From: Hornby, Mark [mailto:Mark.Hornby@lancashire.gov.uk]
Sent: 22 November 2011 15:40
To: Colin Sharpe
Subject: FW: Consultation on planning application 3/2011/0833 Prestons Yard, Longridge Road, Chipping

I would recommend a refusal of this application in its present form on highway safety grounds. The two four bedroom properties have built in garages but with only approximately 3 metres and 3.5 metres respectively between the garage doors and the back of the pedestrian footway. This is insufficient to allow vehicles to pull clear of the highway and footway when entering the driveways and would be a safety hazard to pedestrians and traffic on Longridge Road. A clear 5 metre distance from the back of the footway to the garage doors would be the minimum acceptable.

Proposed Layout Ground Floor

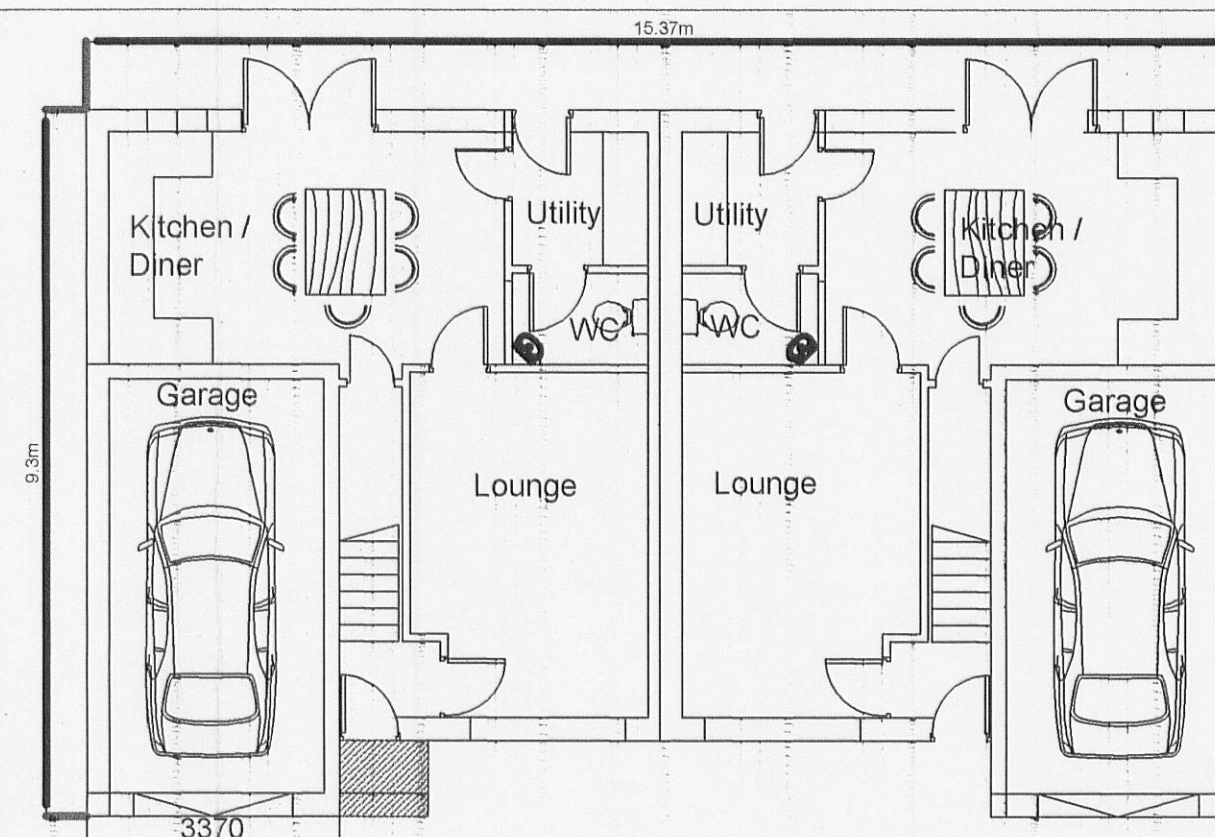
I am pleased to note that the applicant has shown the existing footway to the south west side of the plot being extended along the frontage of the proposed dwellings and would not accept the removal of this to achieve a 5 metre distance from highway boundary to garage door. If the applicant can modify the proposal so that from the existing kerbline of Longridge road there is a 1.5 metre pedestrian footway and then a 5 metre length of driveway to the door of any proposed garages then I would have no objection in principle to the proposals, subject to the usual conditions relating to gates, surfacing and so forth.
